**KIRKLEES METROPOLITAN COUNCIL
INVESTMENT & REGENERATION SERVICE**

**DELEGATED DECISION FOR DISCHARGE OF CONDITION A.4 -
NOTIFICATION OF A PROPOSED ENLARGEMENT TO DWELLINGHOUSE**

Reference no.	2021/HH/94549/W
Site Address	75, Imperial Road, Edgerton, Huddersfield, HD1 4PG
Description	The proposal is for erection of single storey rear extension. The extension projects 6m beyond the rear wall of the original dwelling house. The maximum height of the extension is 4m, the height of the eaves of the extension is 3m
Recommending Officer	Lucy Taylor

Location & Site Plan

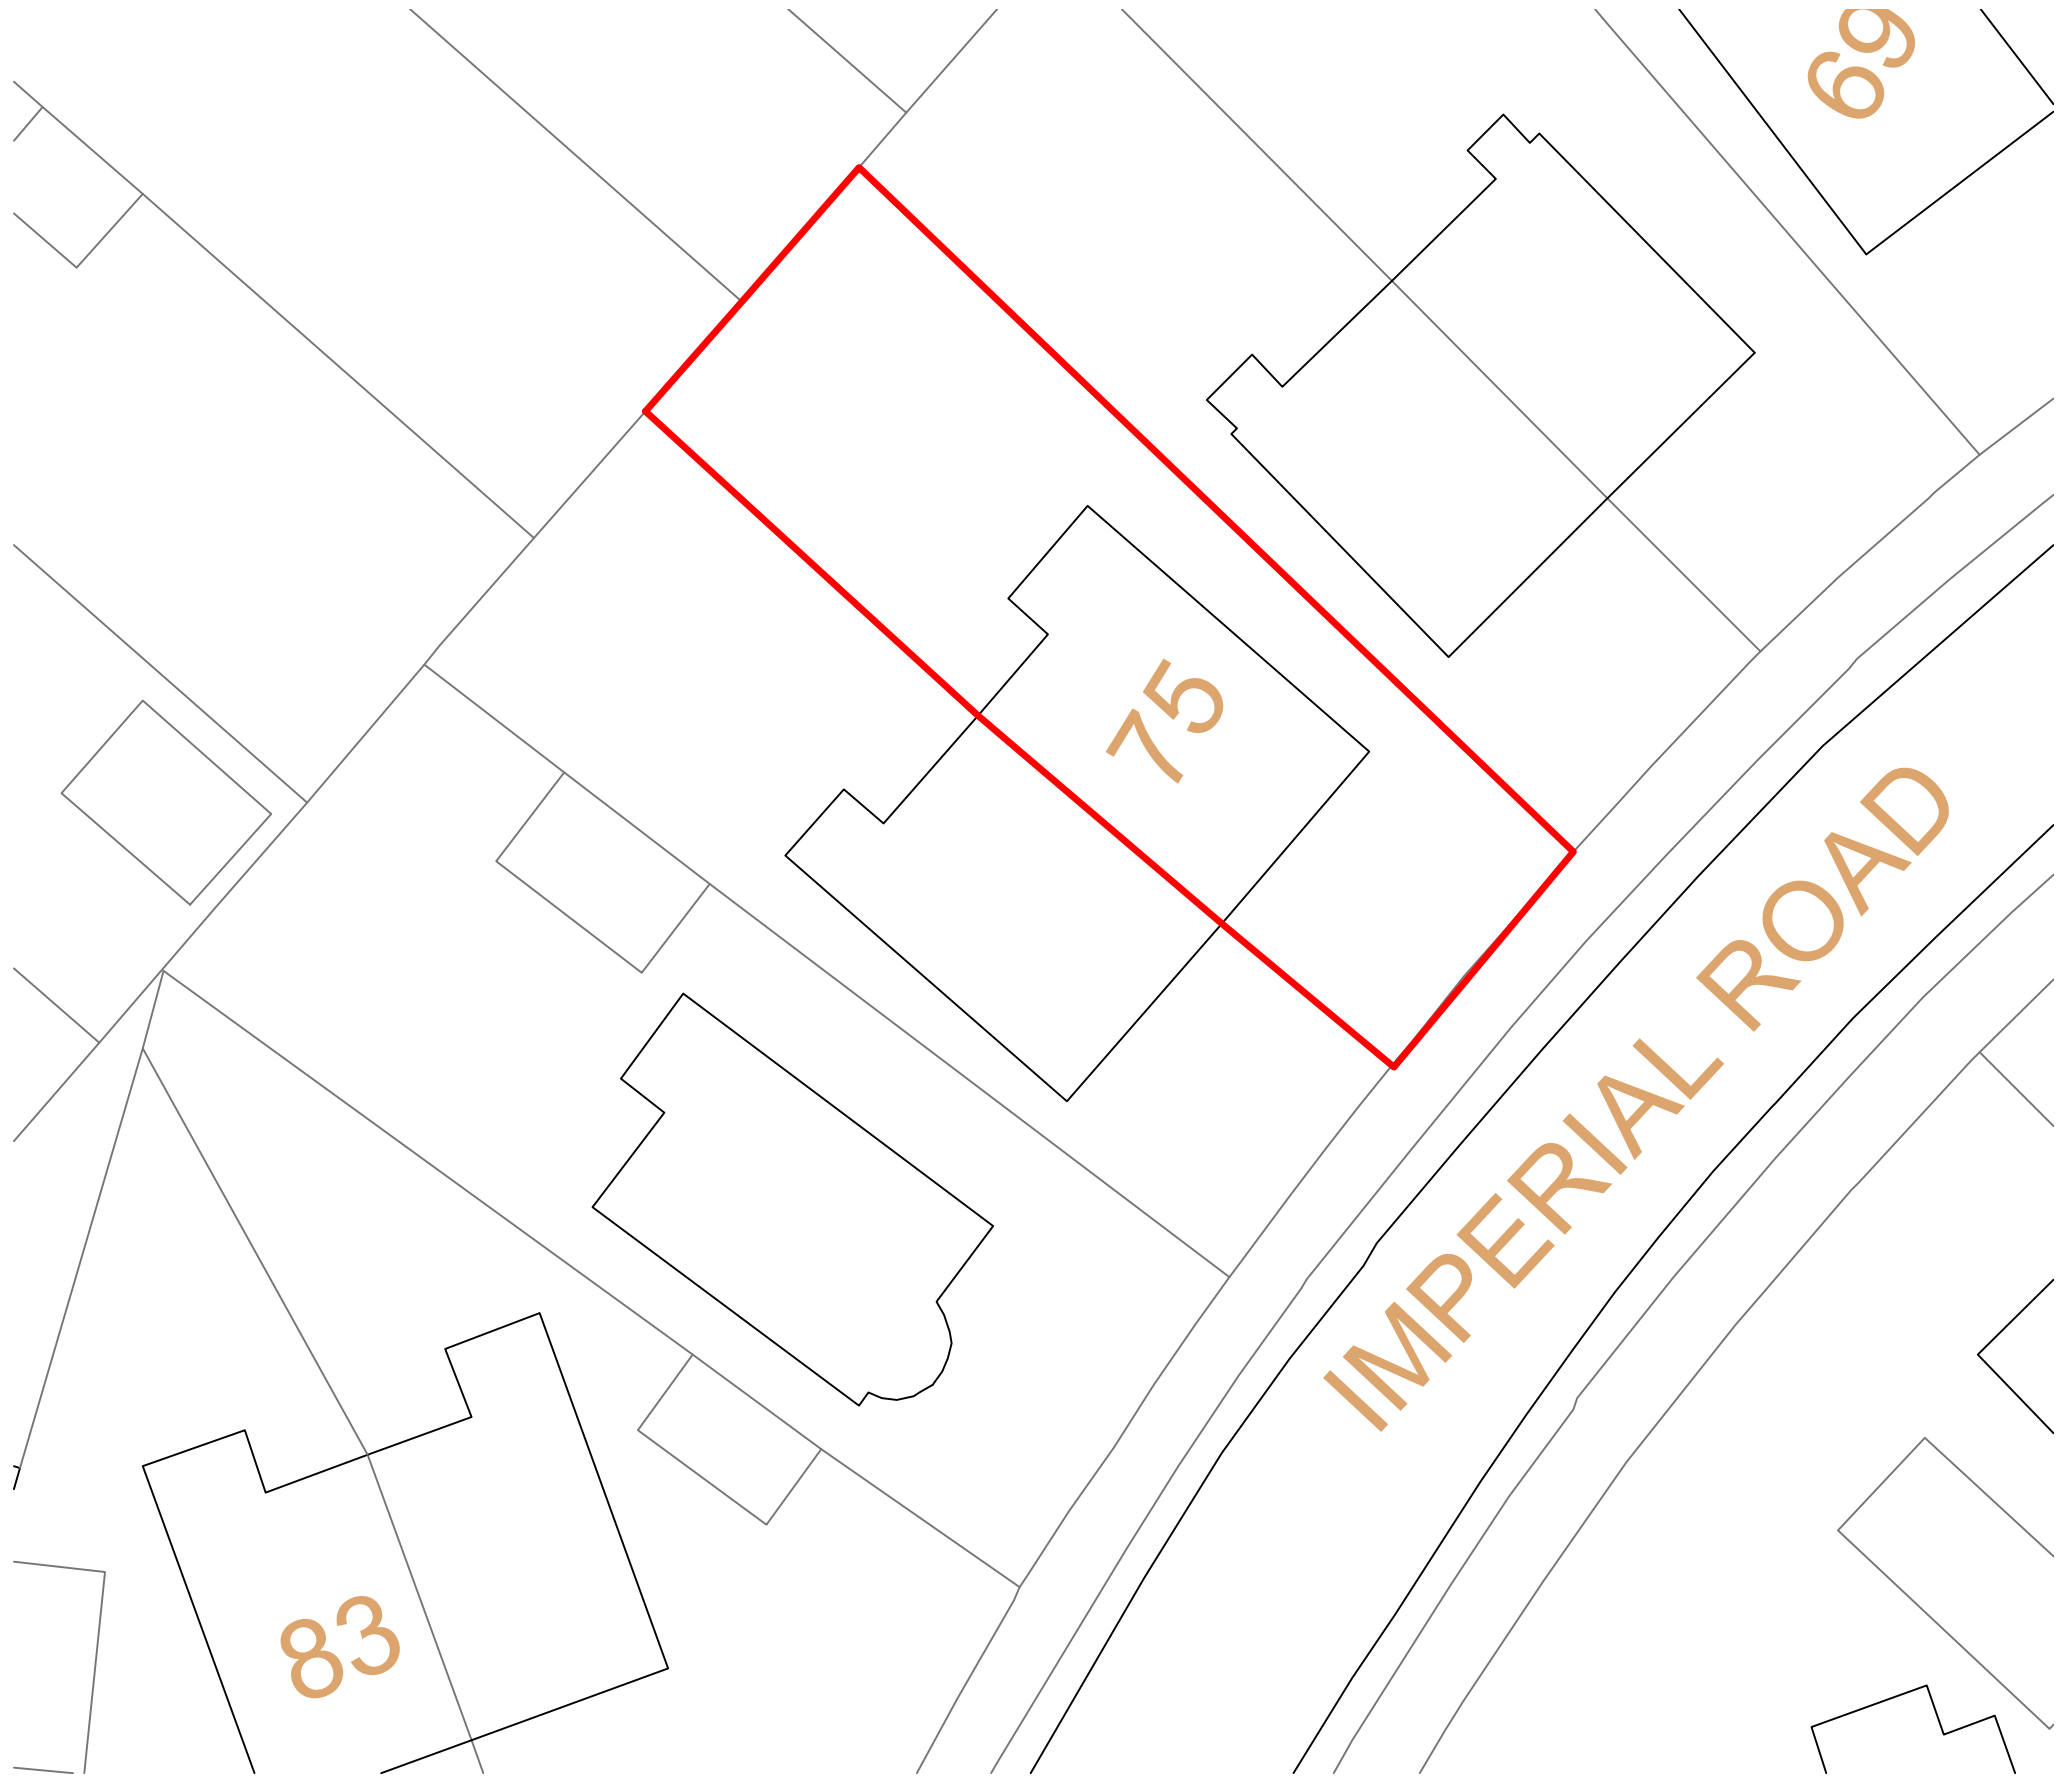
The proposal fails to comply with sub-paragraph j(iii) of Class A, Part 1 of Schedule 2 of the Town and Country Planning (General Permitted Development) Order 2015 (as amended) by reason that the proposed extension would project beyond an original side elevation of the dwellinghouse (original rearward projection) and have a width greater than half the width of the original dwellinghouse.

This is because the proposed extension would project beyond an original side elevation of the dwellinghouse and have a width greater than half the width of the original dwellinghouse.
